Application for a non-material amendment following a grant of planning permission.

EXTENSION AND CHANGE OF USE FROM BUILDERS
YARD AND OFFICES TO FORM 4 NO. 1 BEDROOM FLATS

FP/208/08

RE-LOCATION OF WASTE BINS SPACES
REDUCTION OF SOME WINDOW SIZES AND ADJUSTMENT OF
POSITIONS TO COMPLY WITH CURRENT BUILDING REGULATIONS

Drawn by: P. O' NEILL	Date: OCTOBER, 1998
Scale/s 1:100, 1:500, 1:1250	
Drg. no. 9836 / 02	Rev. L

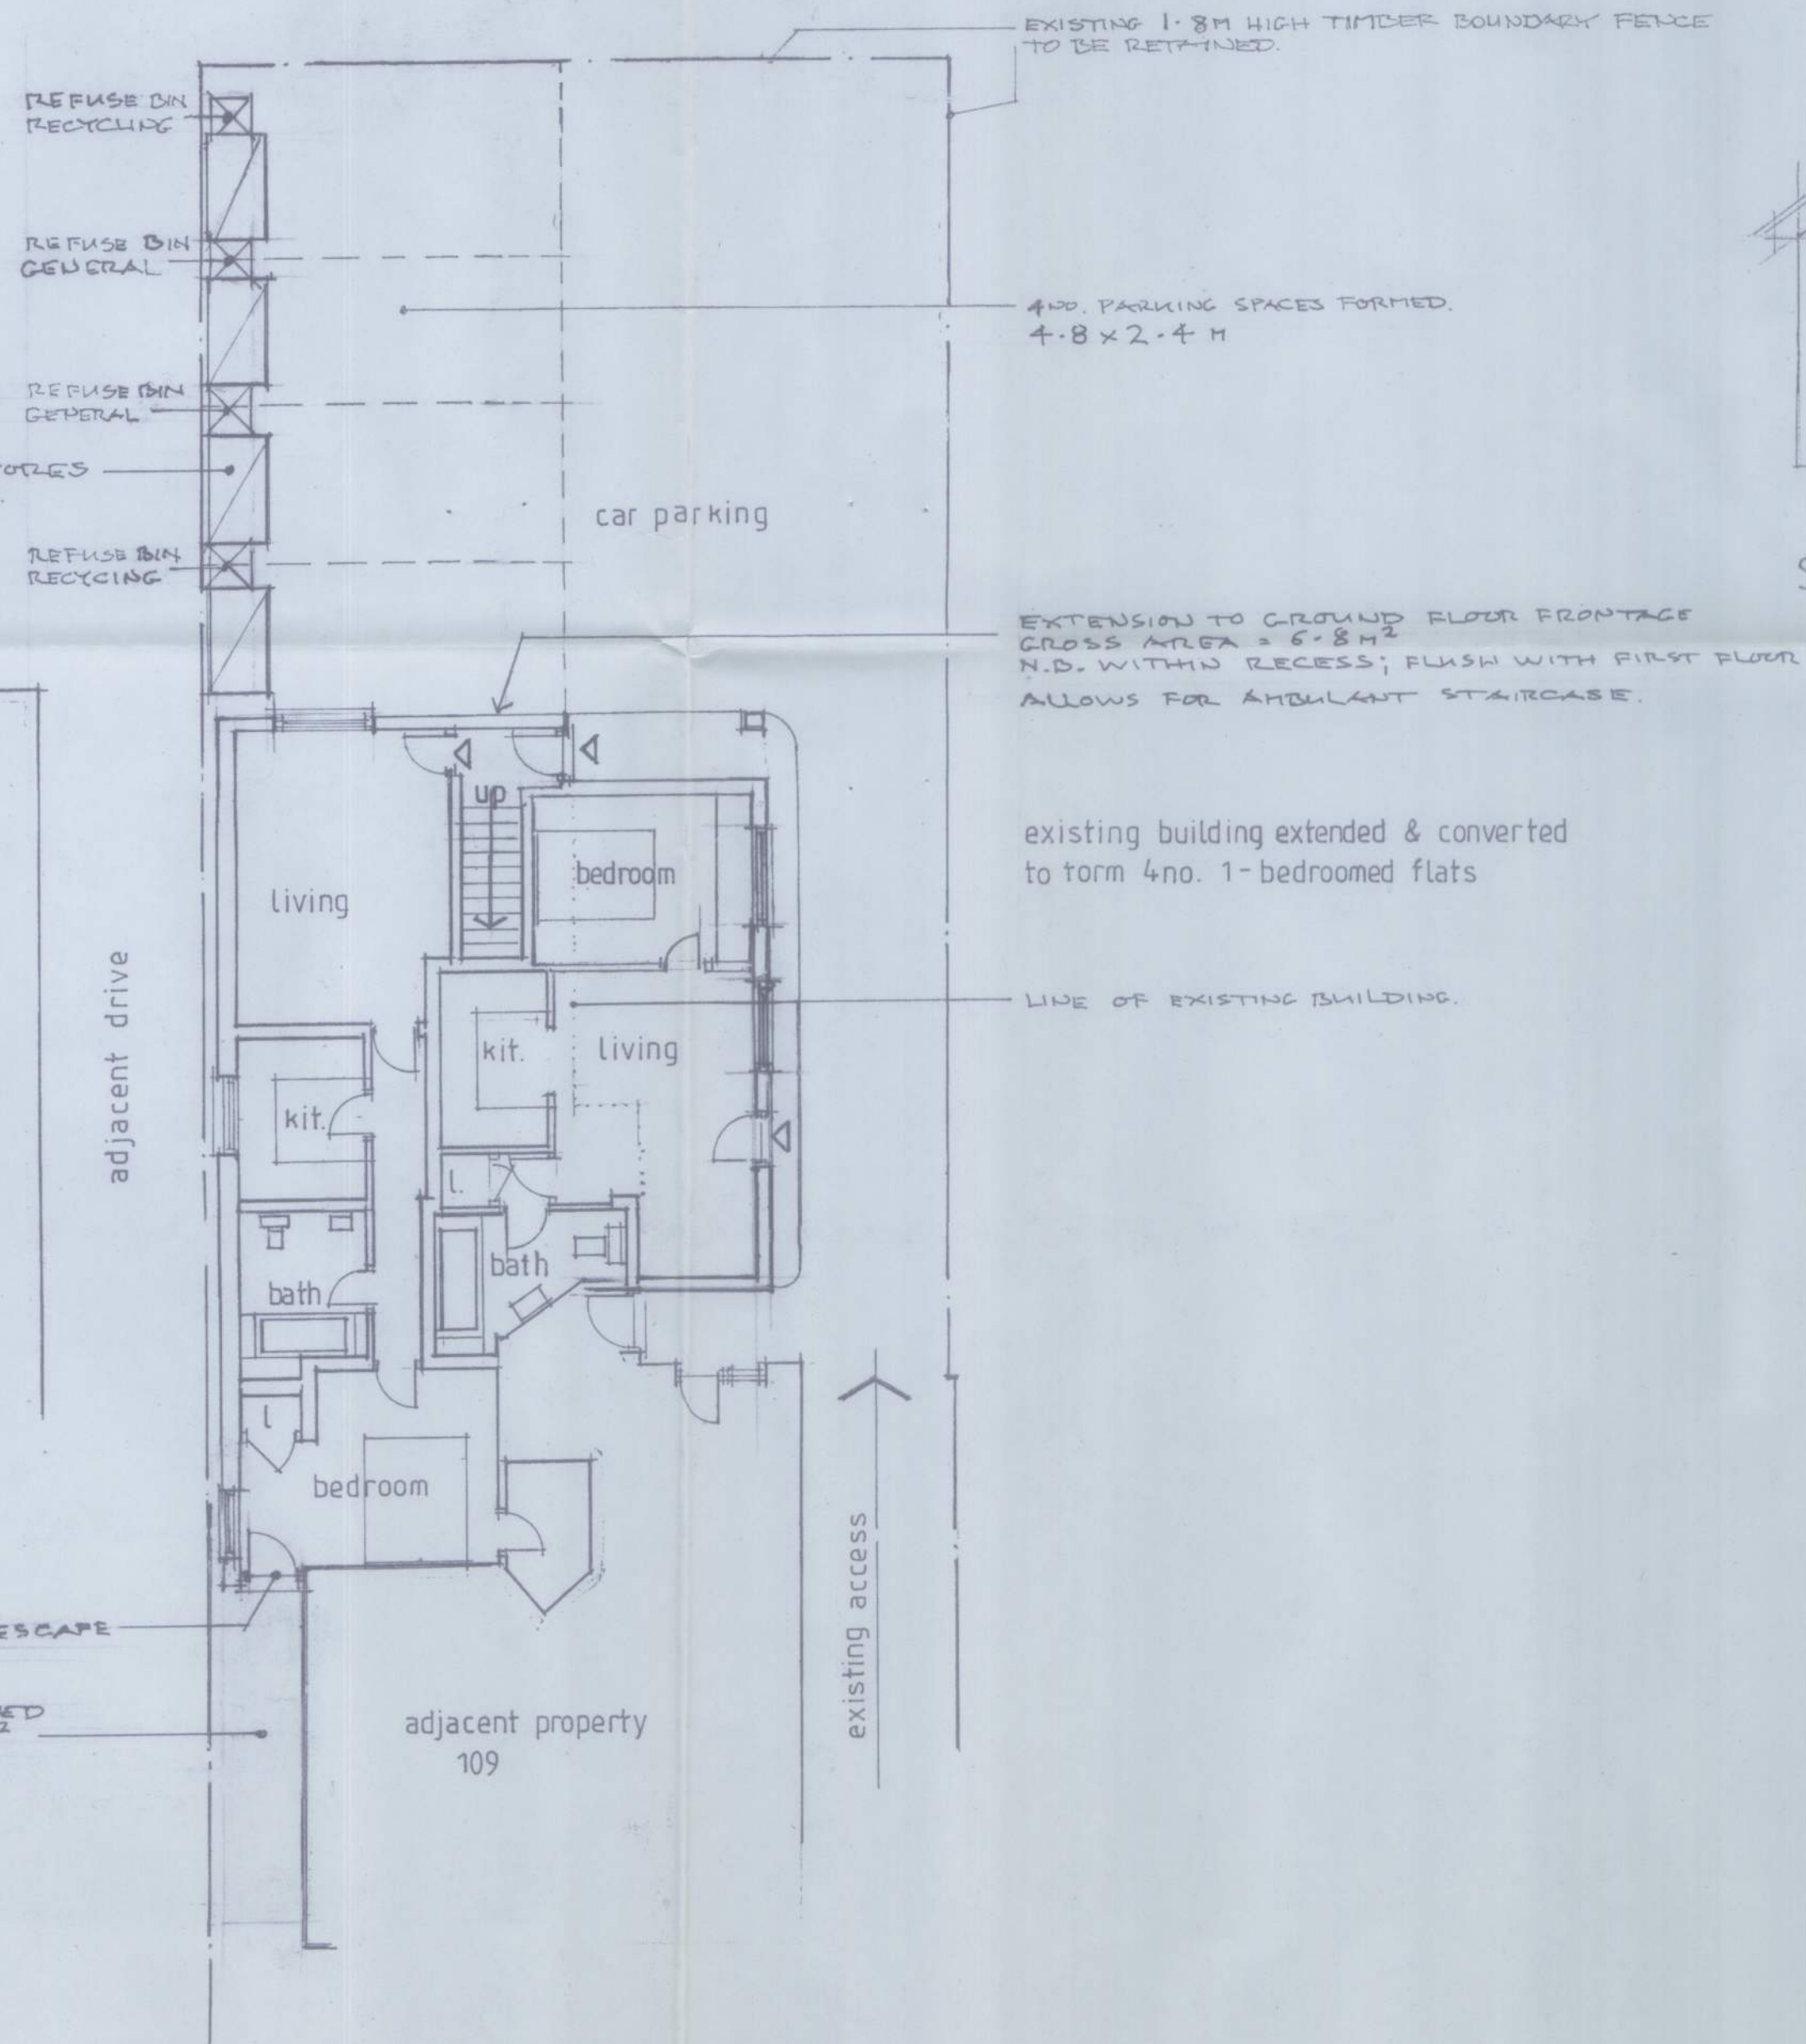
TO COMPLY WITH CURRENT BUILDING REGULATIONS AND
REQUEST FROM NEIGHBOURS
